Your Ref: OWPC22998
Our Ref: FG/42/19/HH 05-04-2019
Please ask for:
Zac Denton

Single storey front extension, side extension, conversion of garage to habitable use and conversion of roofspace to habitable use to include a rear dormer and 3 front rooflights.

22 Singleton Crescent Ferring

PROPOSED WEST
ELEVATION 1:100

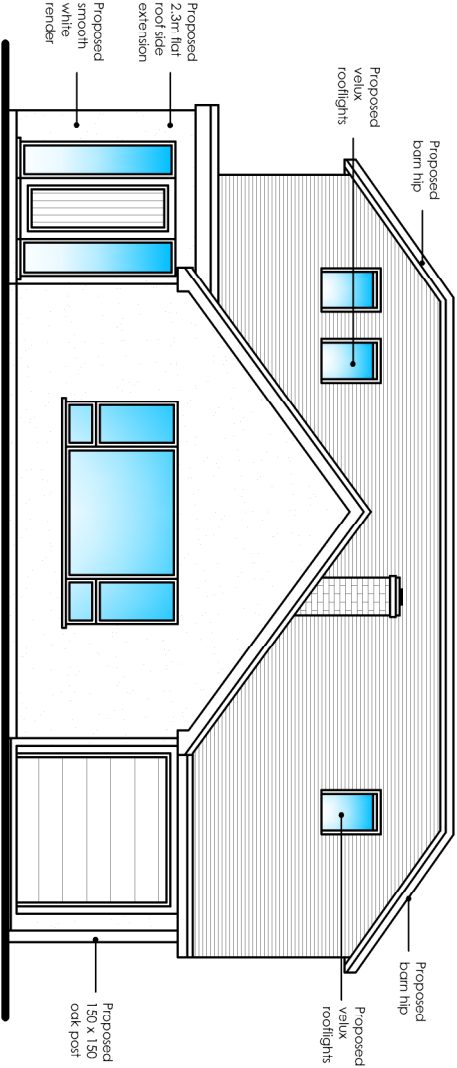
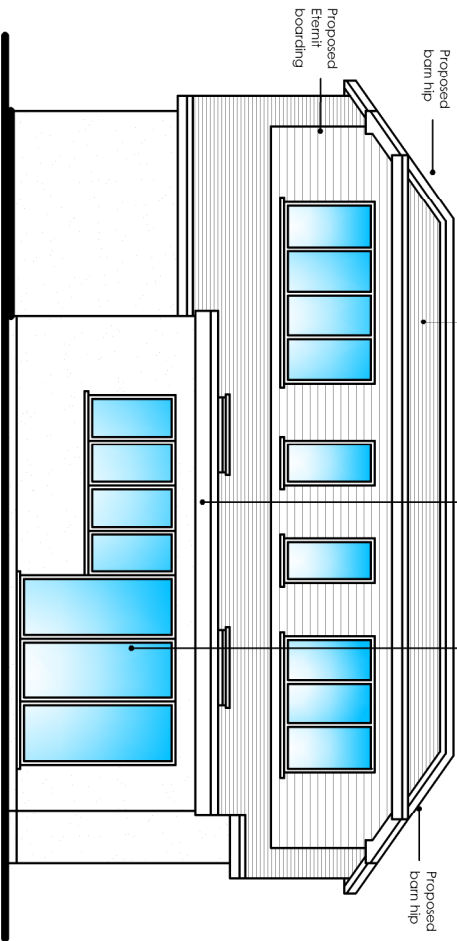
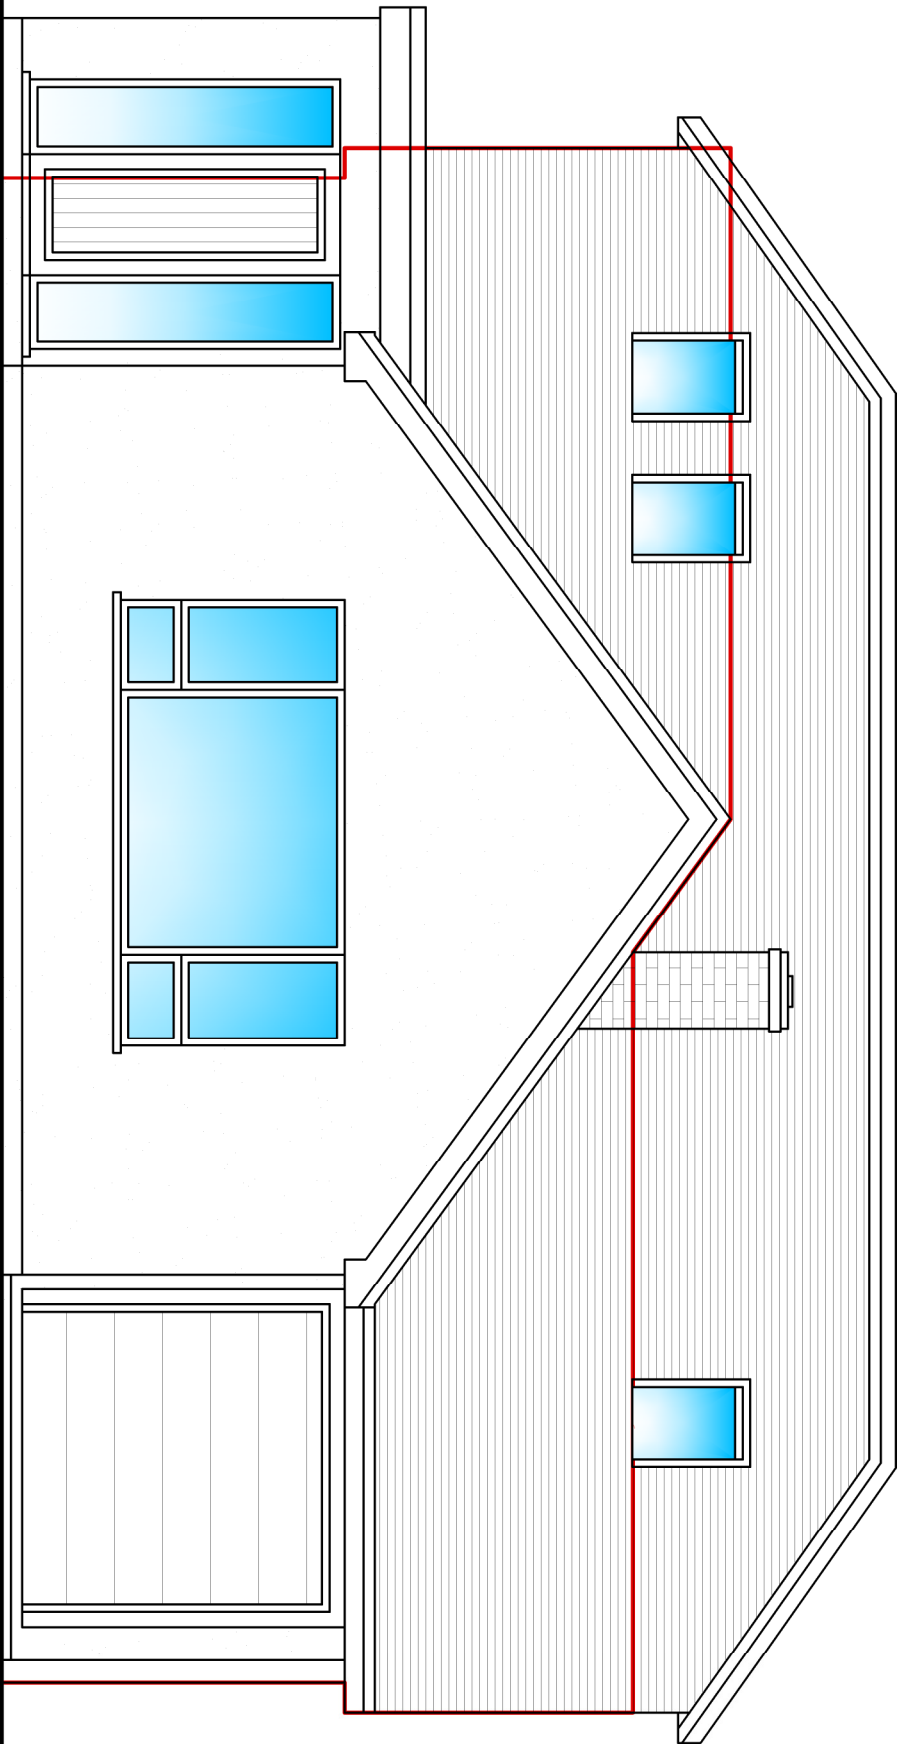
Singleton Crescent was constructed in the early 1960s, well laid out with bungalows on good-sized plots, achieving a harmonious overall effect. The front elevation of the proposed extension is a grotesque intrusion into that harmony. It is completely out of character and quite different from the habitable roof space the Council approved for the bungalow at 27 Singleton Crescent.

PROPOSED SECTION 1:50

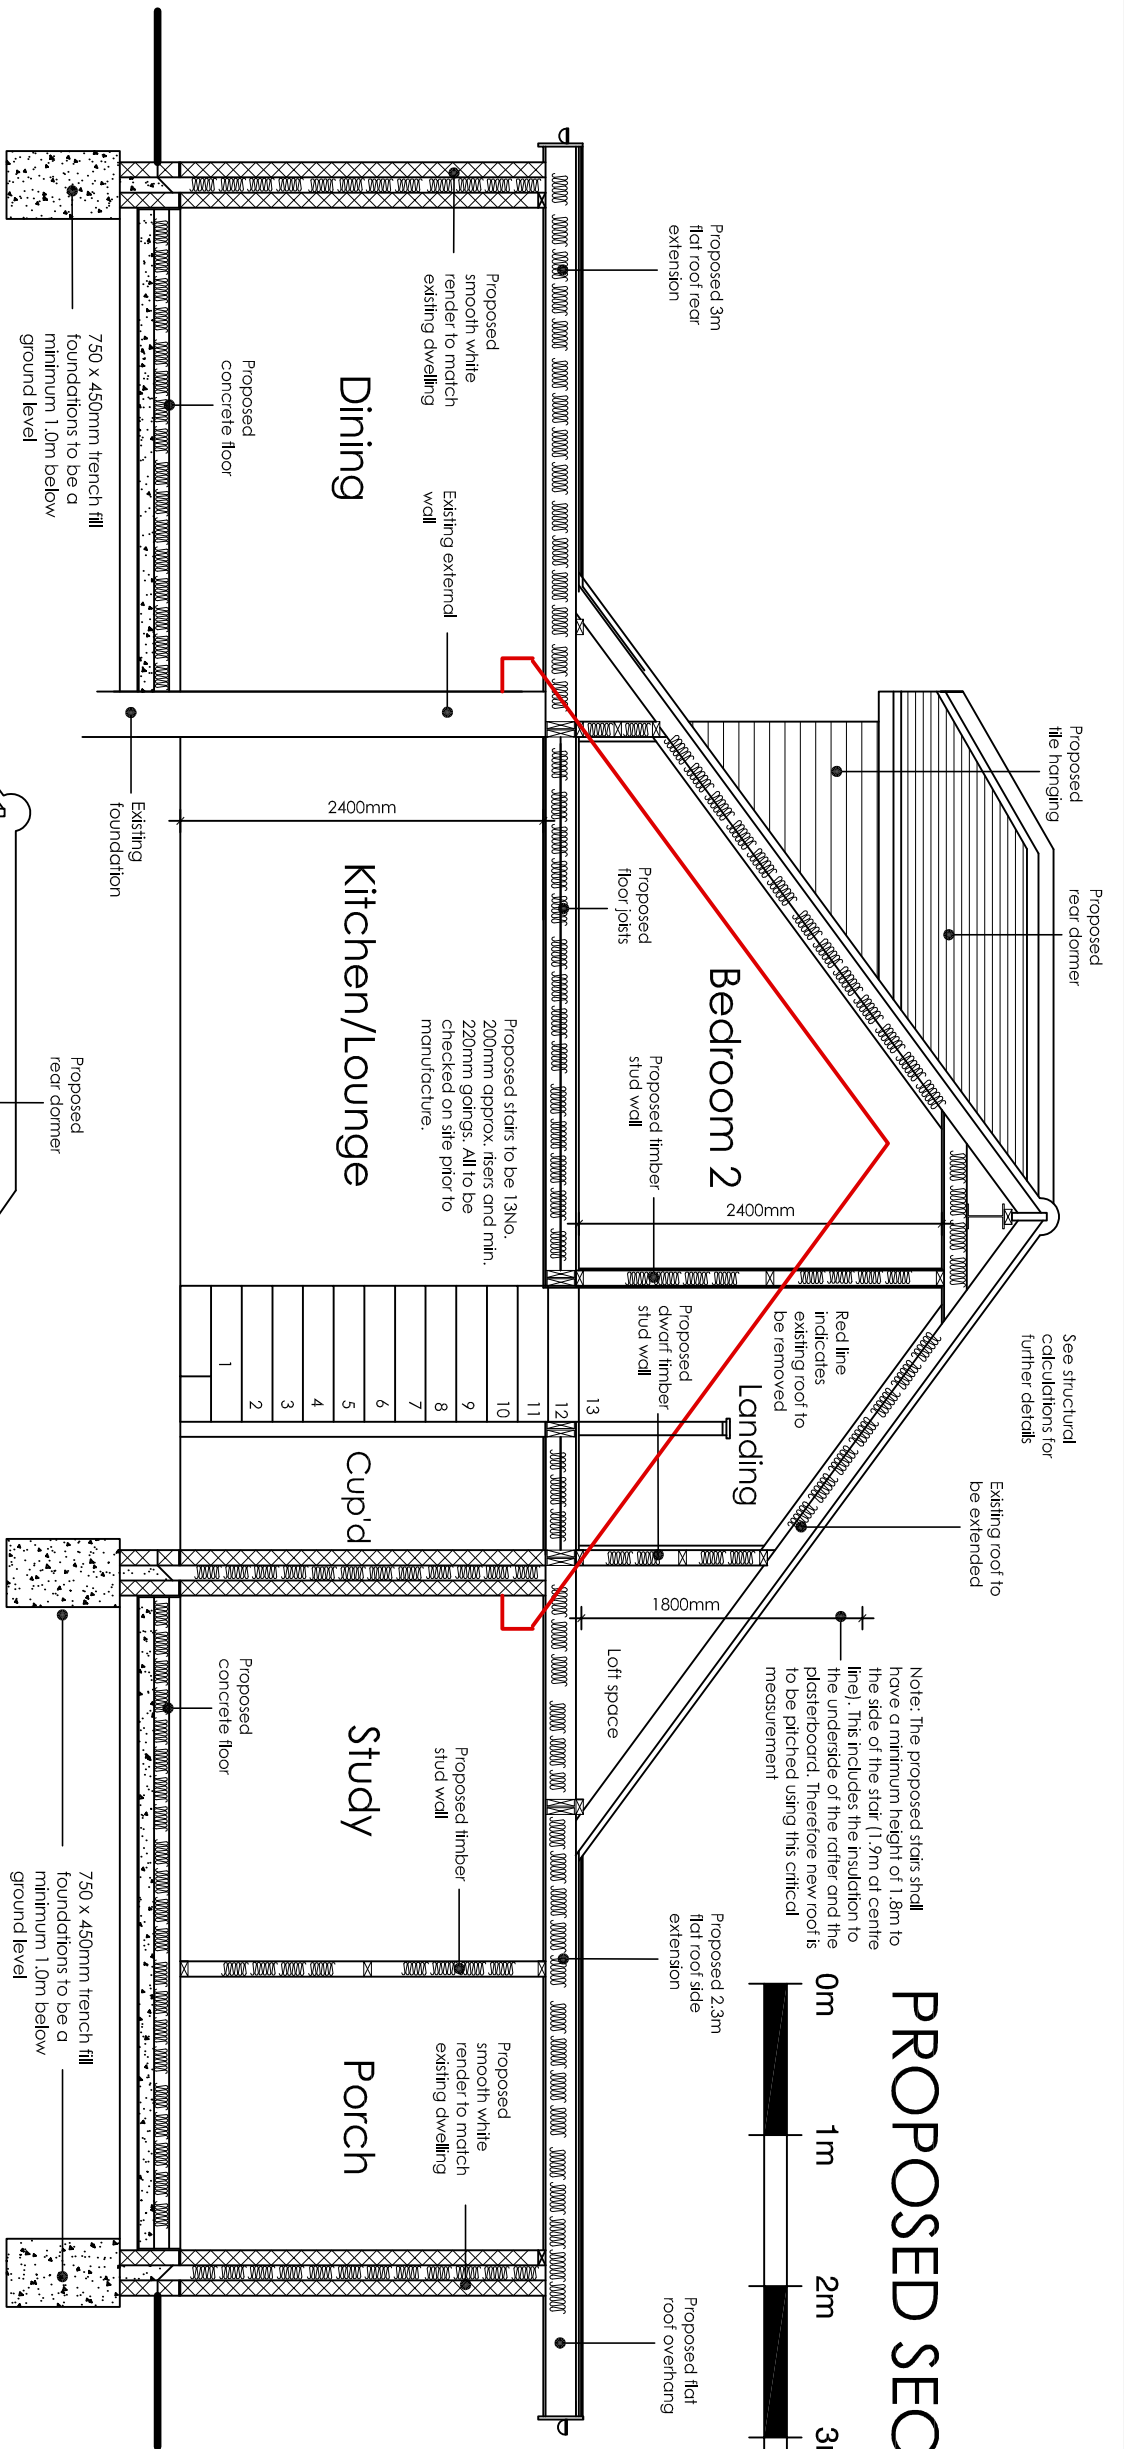
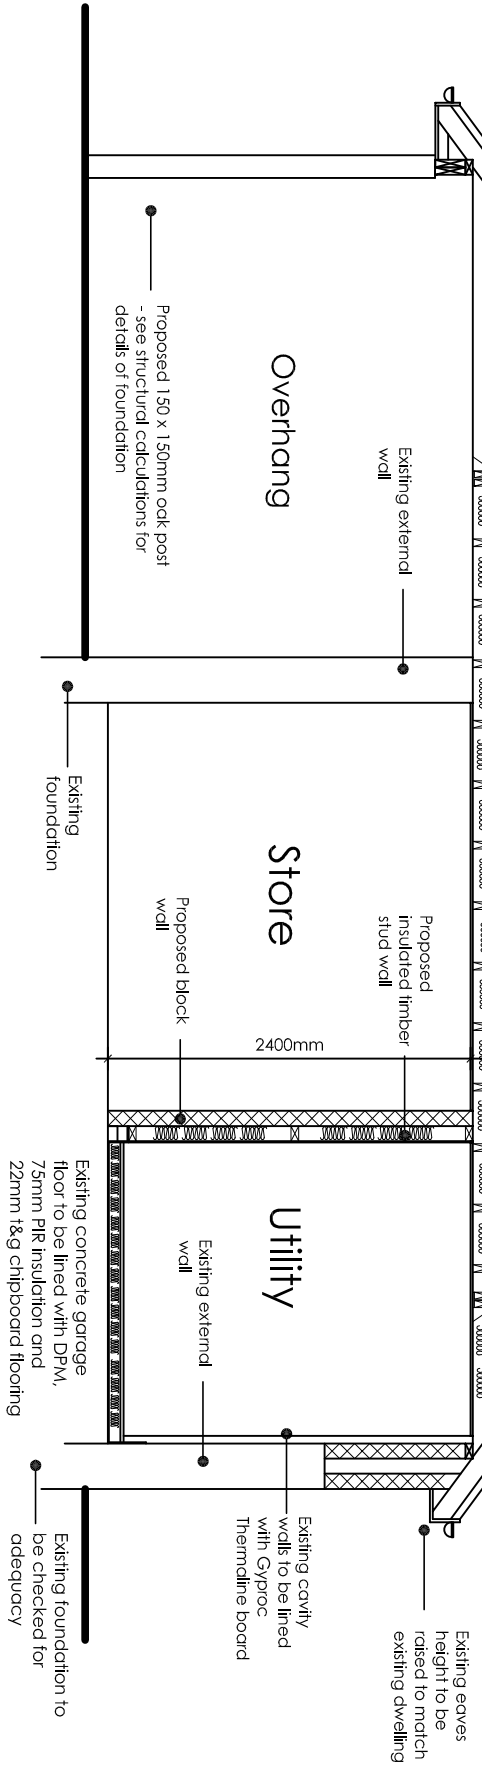
Finally, this huge extension (including the rear ground-floor extension) would be overbearing on the neighbours (especially No. 24) and unnecessarily detract from their privacy and amenity. It is a most un-neighbourly proposal.
